**Application for a non-material amendment following a grant of planning permission,
Town and Country Planning Act 1990**

**Non material amendment to previous permission 2026/90186 for erection of first
floor extension over existing garage
12, Thorncliff Green Road, Kirkburton, Huddersfield, HD8 0UQ
Application Number: 2026/91509**

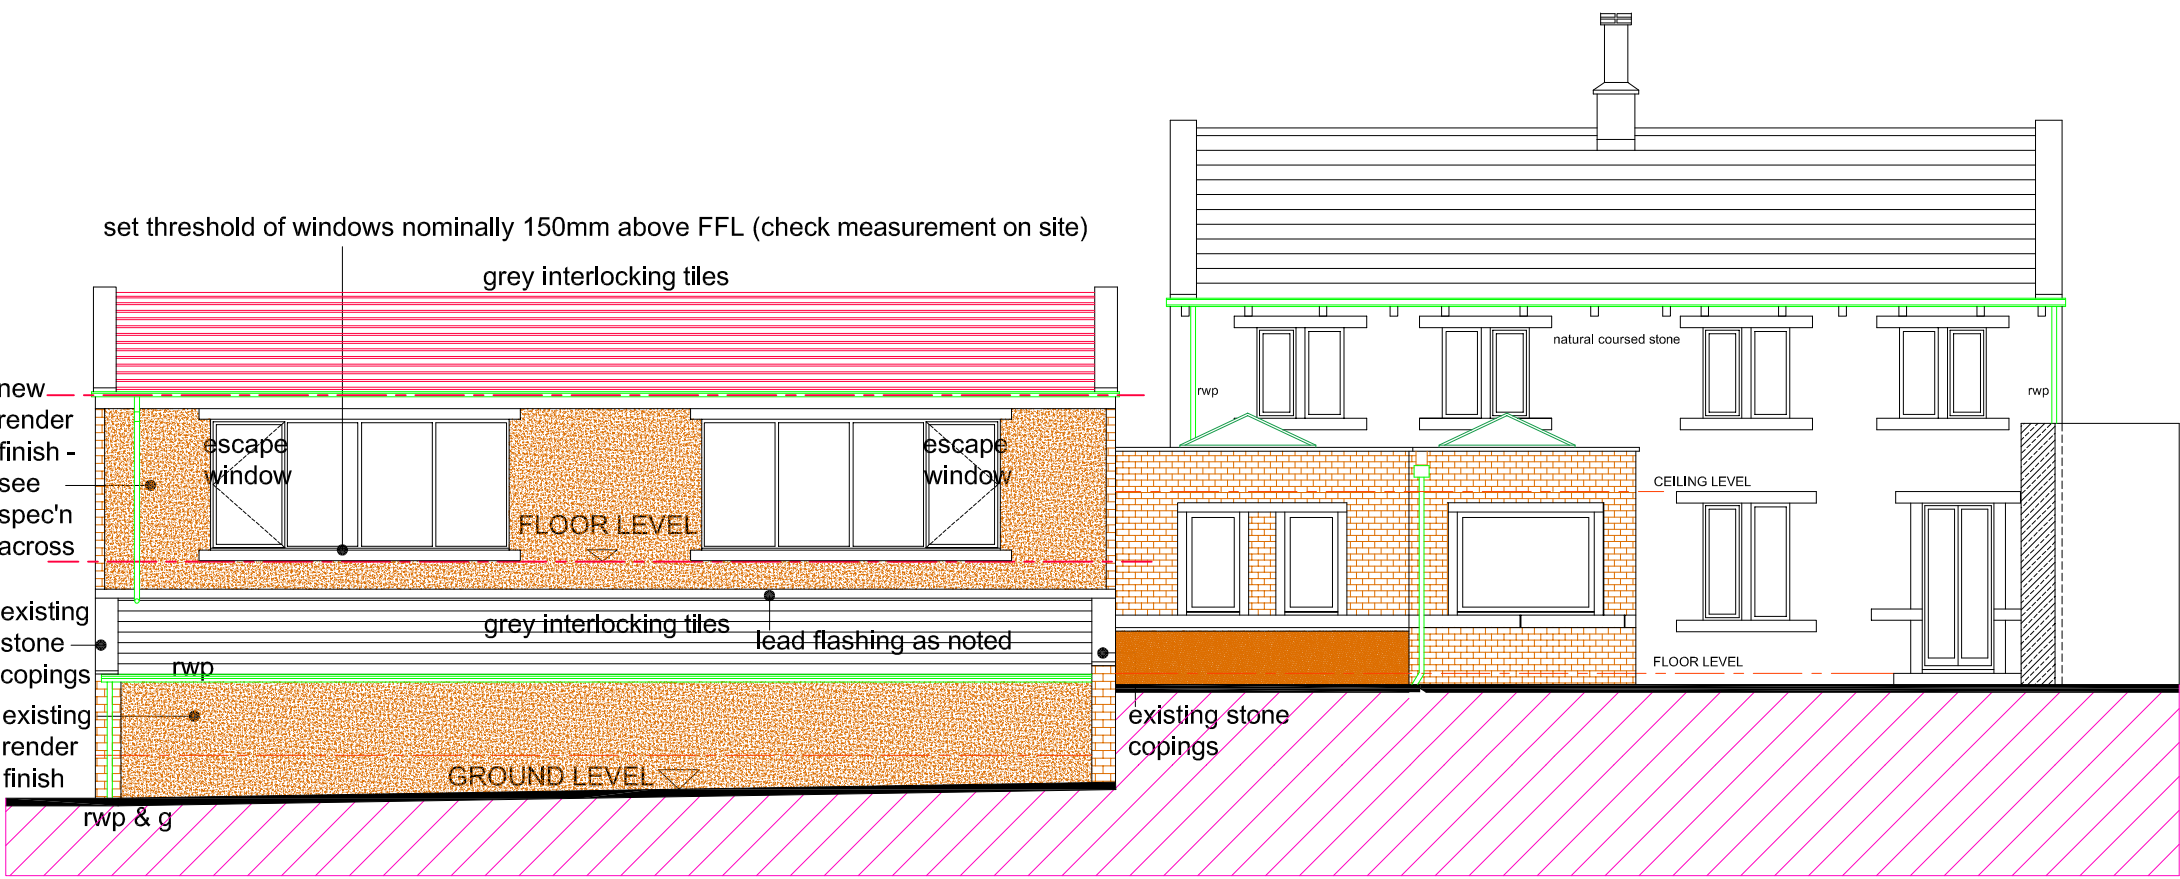
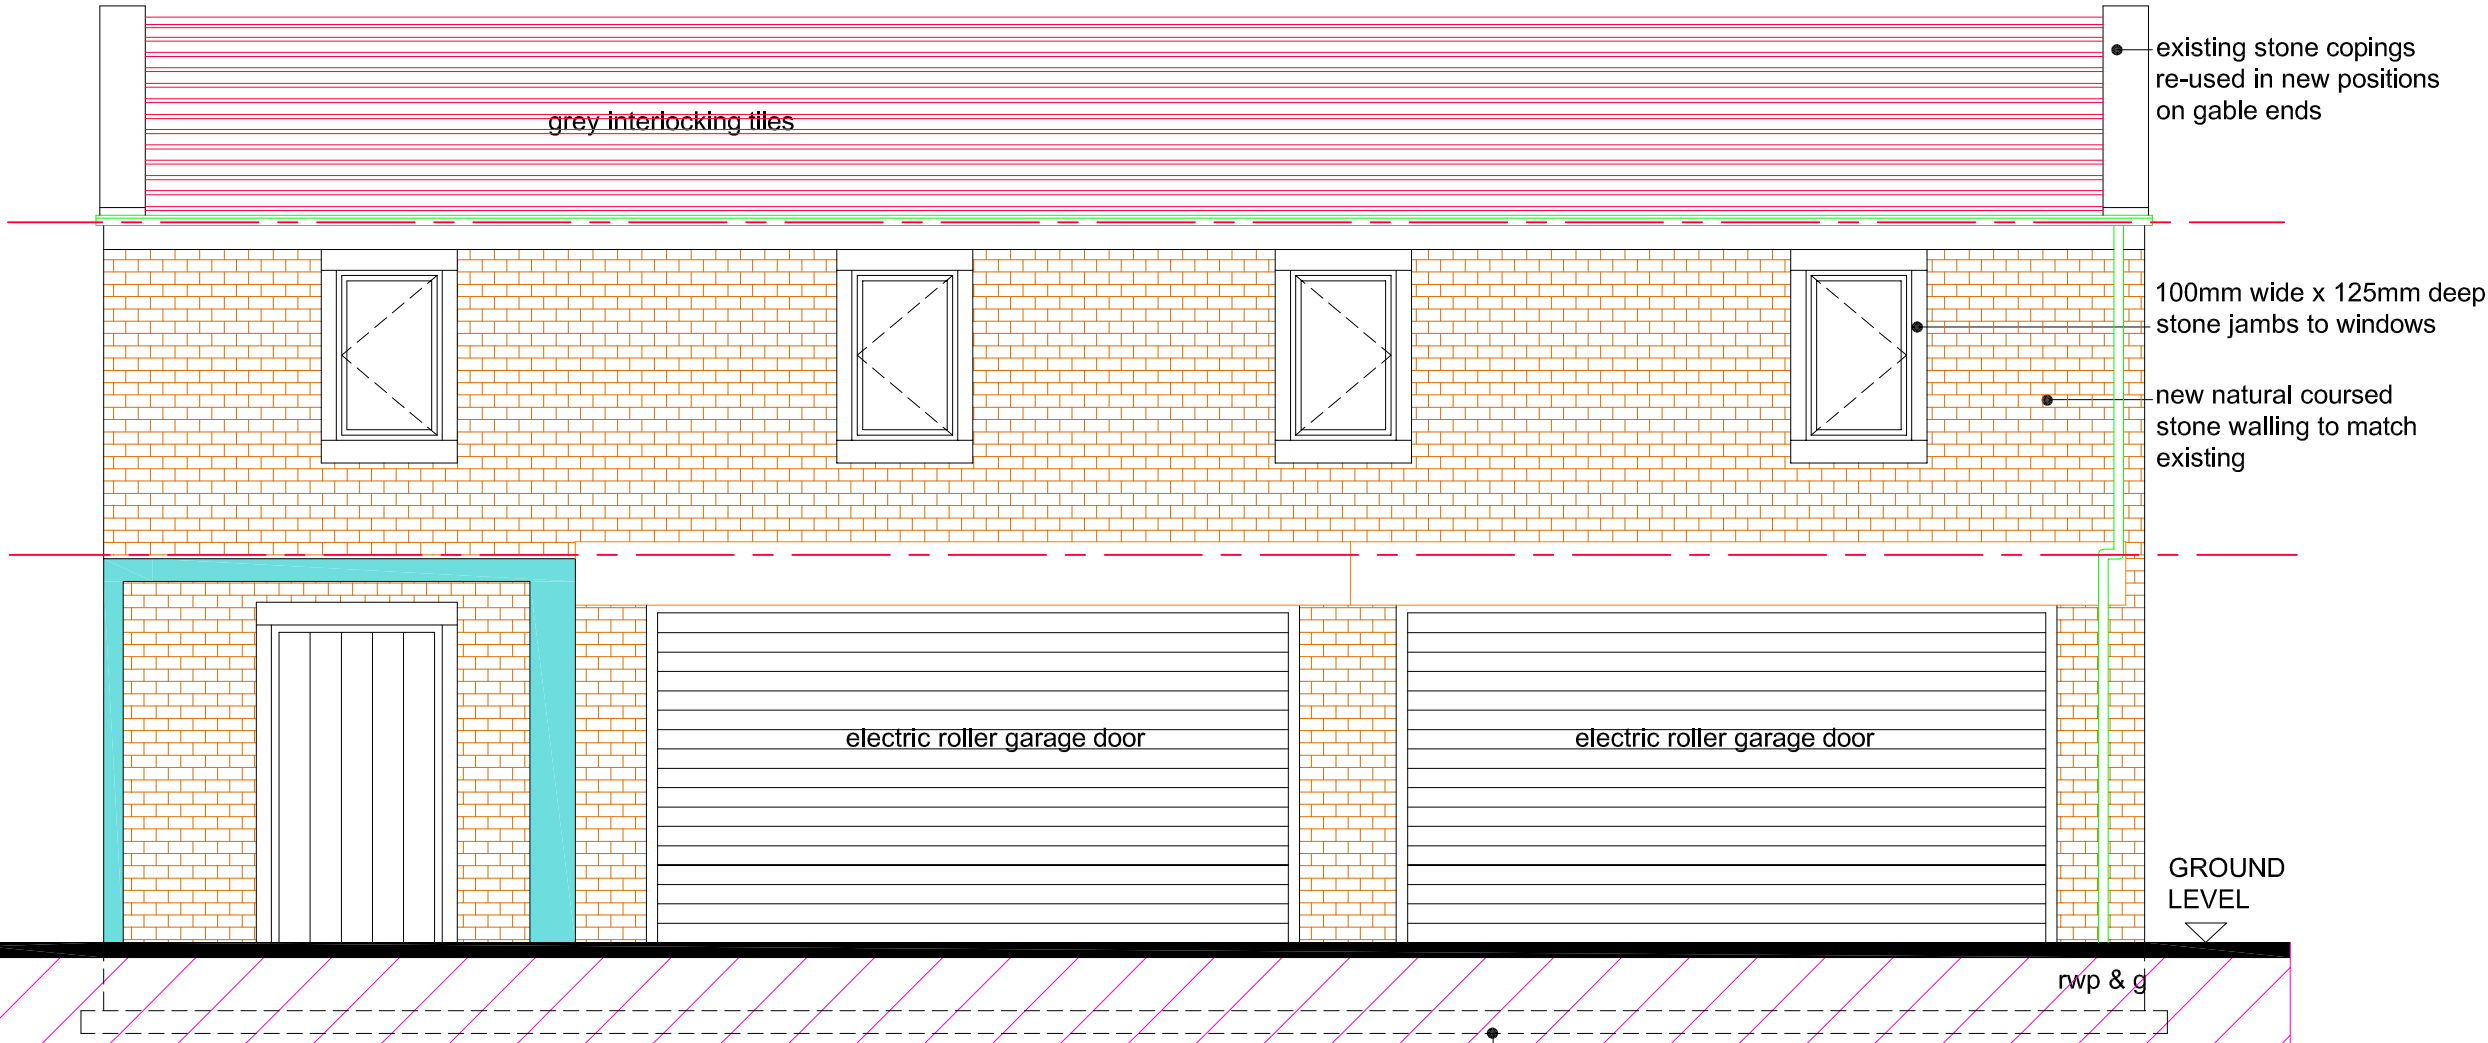
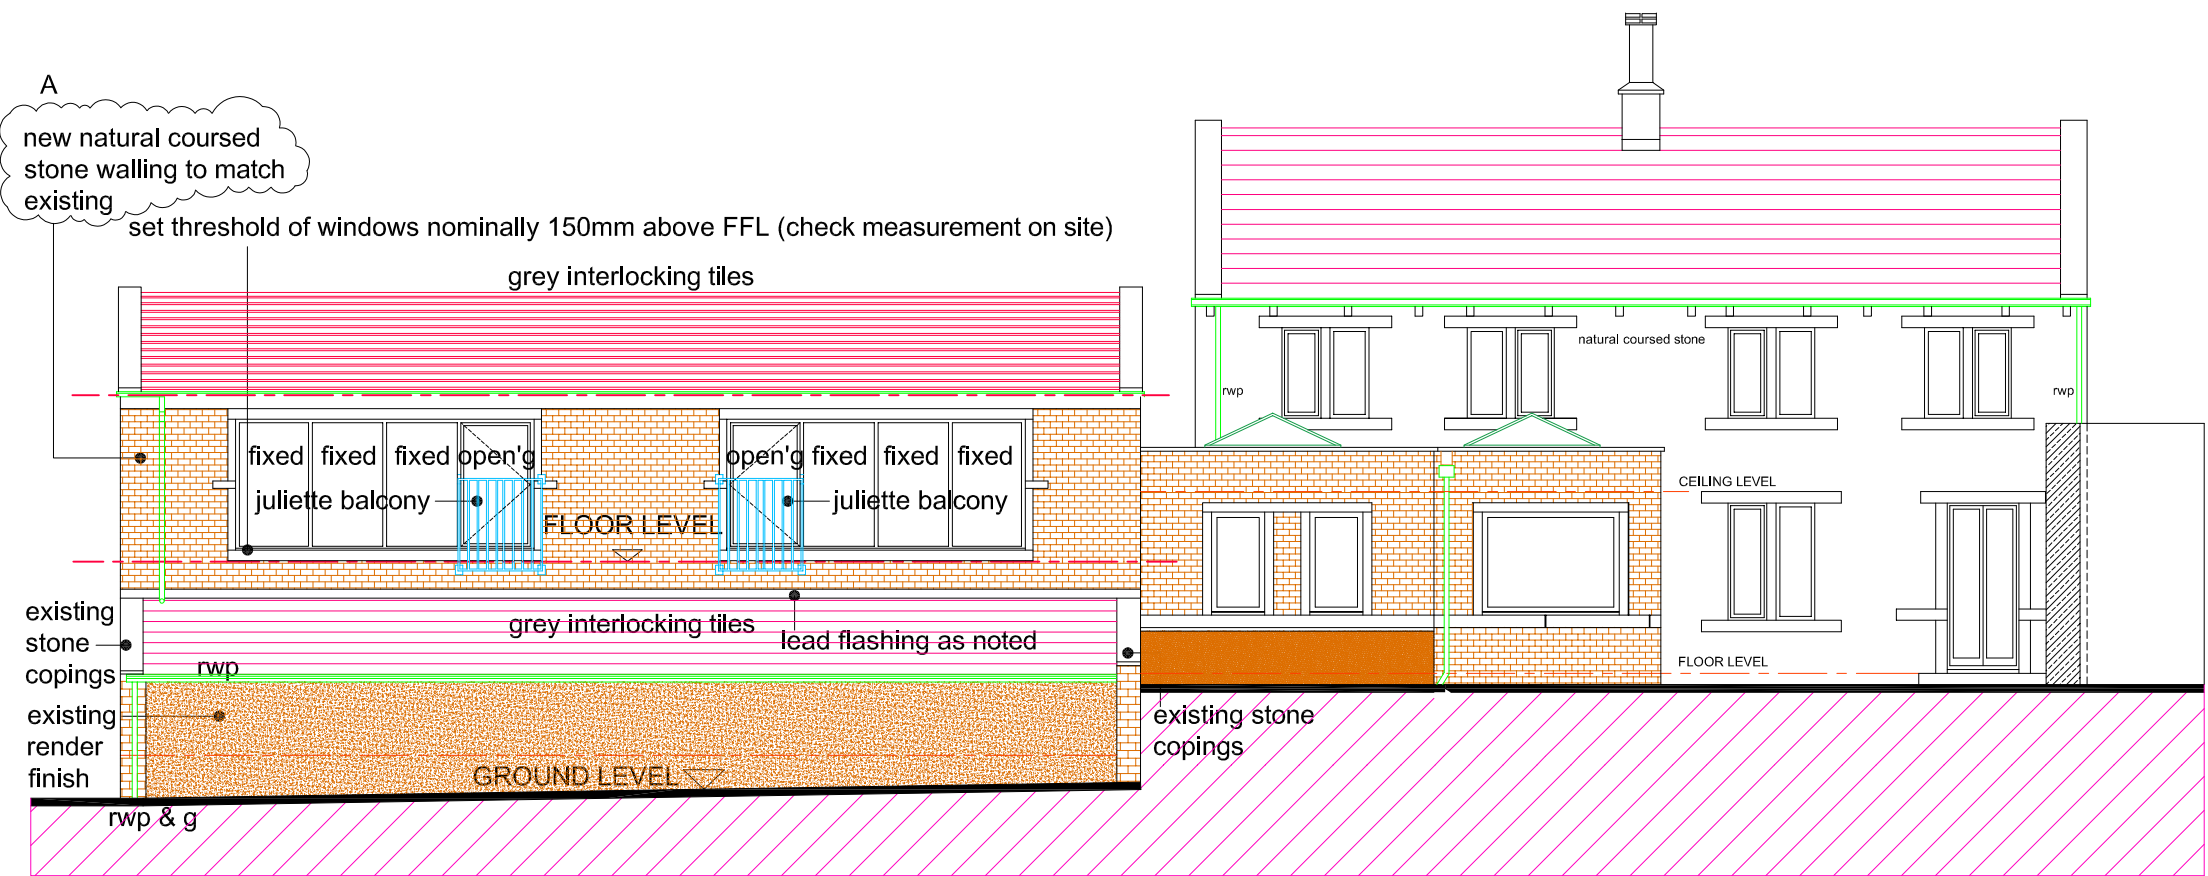
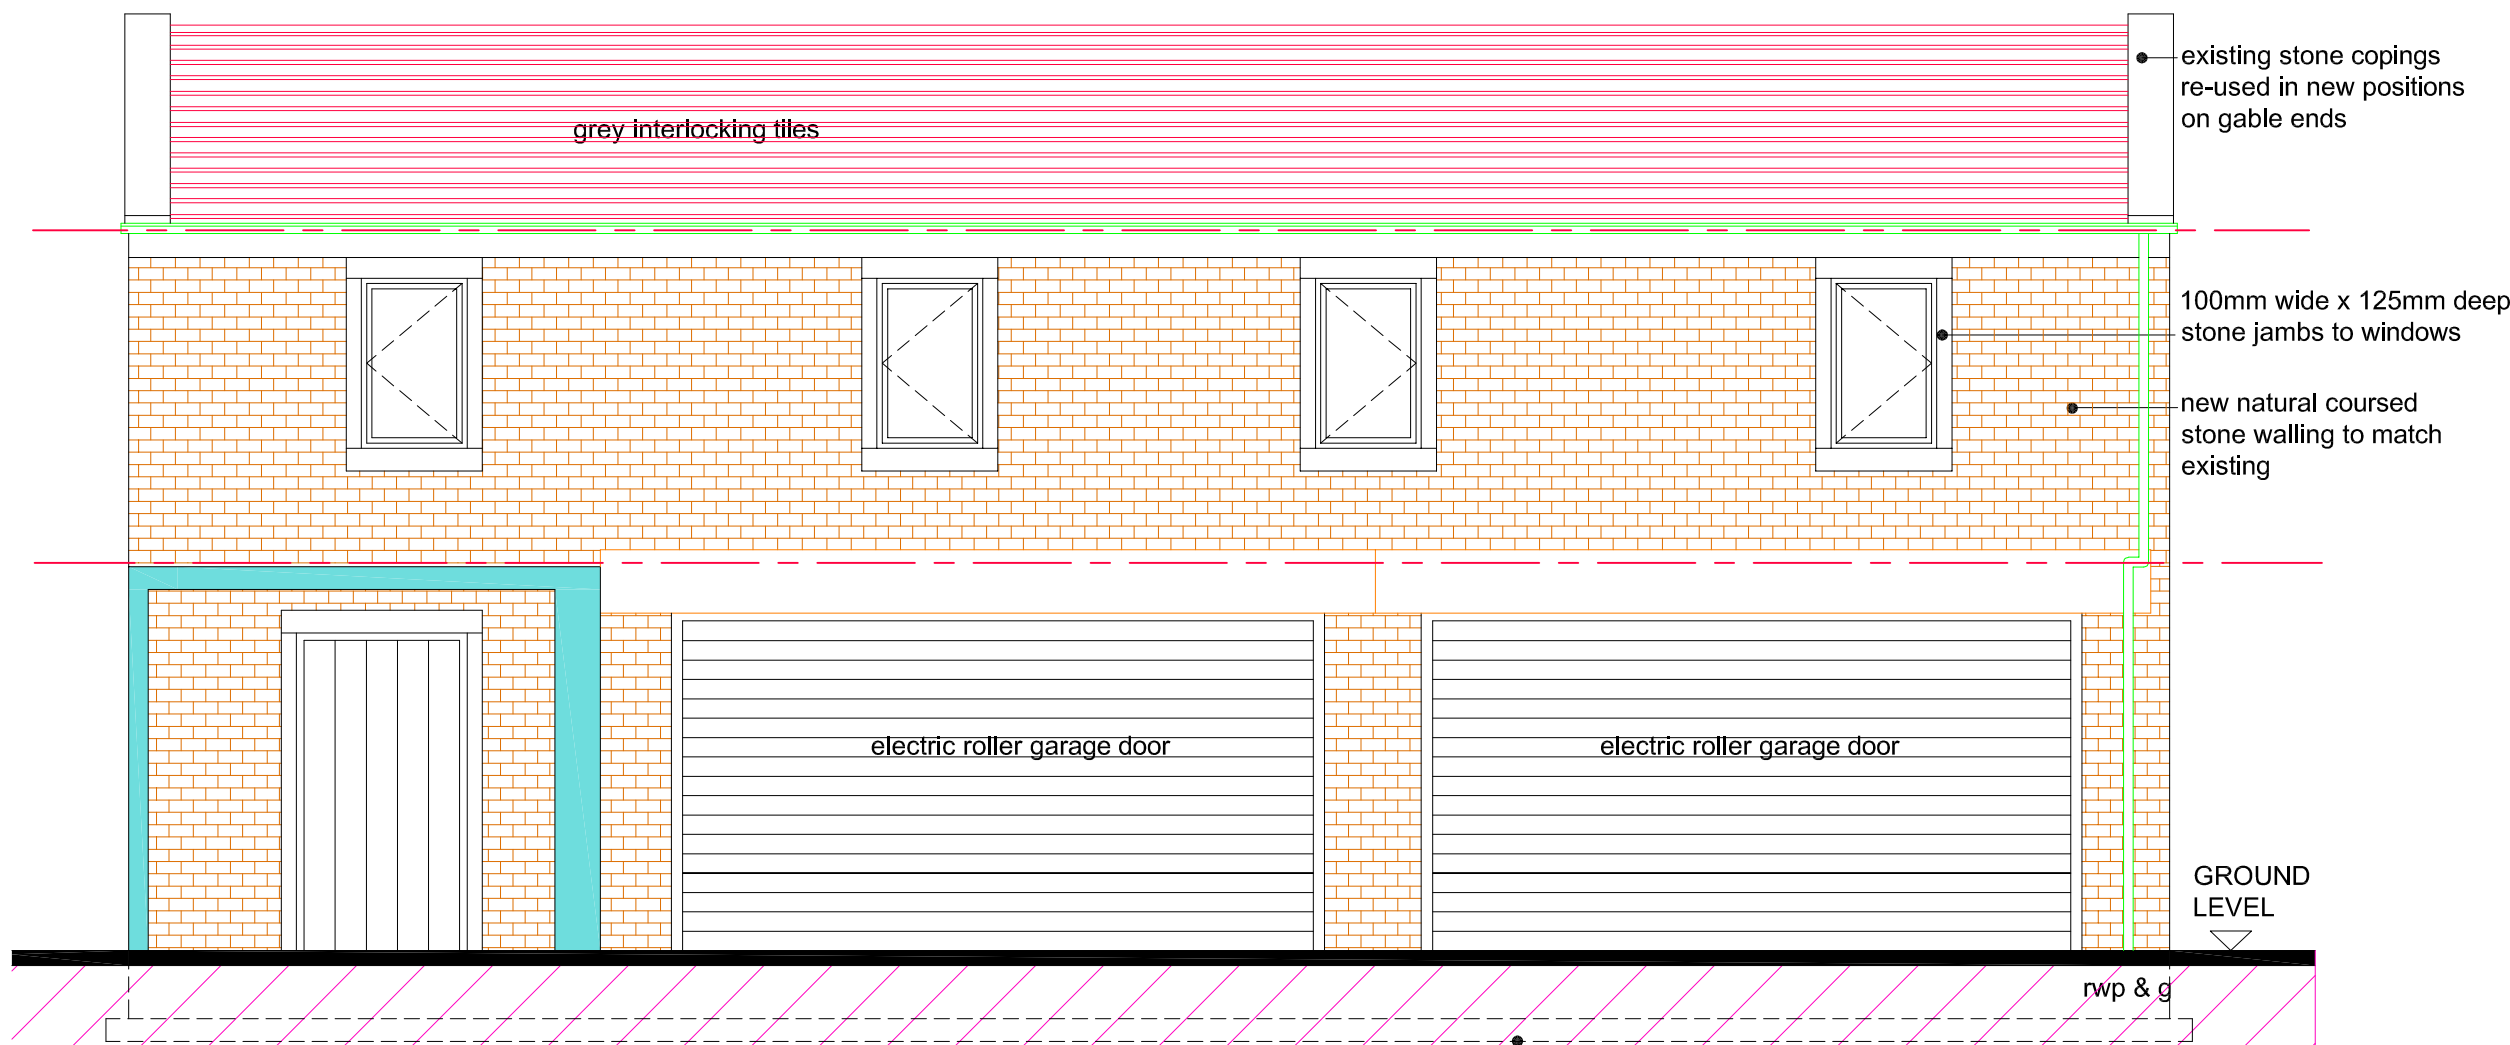
Thank you for your application dated 03-Jun-2026 for a non-material amendment to the above scheme. The amendment seeks to use stone instead of render to the walls and the installation of Juliette balconies on the rear elevation windows. The amendments are shown on plan (KBH) PD 06 submitted 03/06/2026.

I confirm that the alterations are acceptable and may be considered as a non-material amendment to the approved drawings. It should be noted that this letter relates only to the non-material amendment sought and it is not a re-issue of the original planning permission. The two documents should be read together and as such, all conditions imposed on the original granting of planning permission apply to the proposal as now amended. A copy of this letter and the amended plans will be retained on the public record of approved documents.
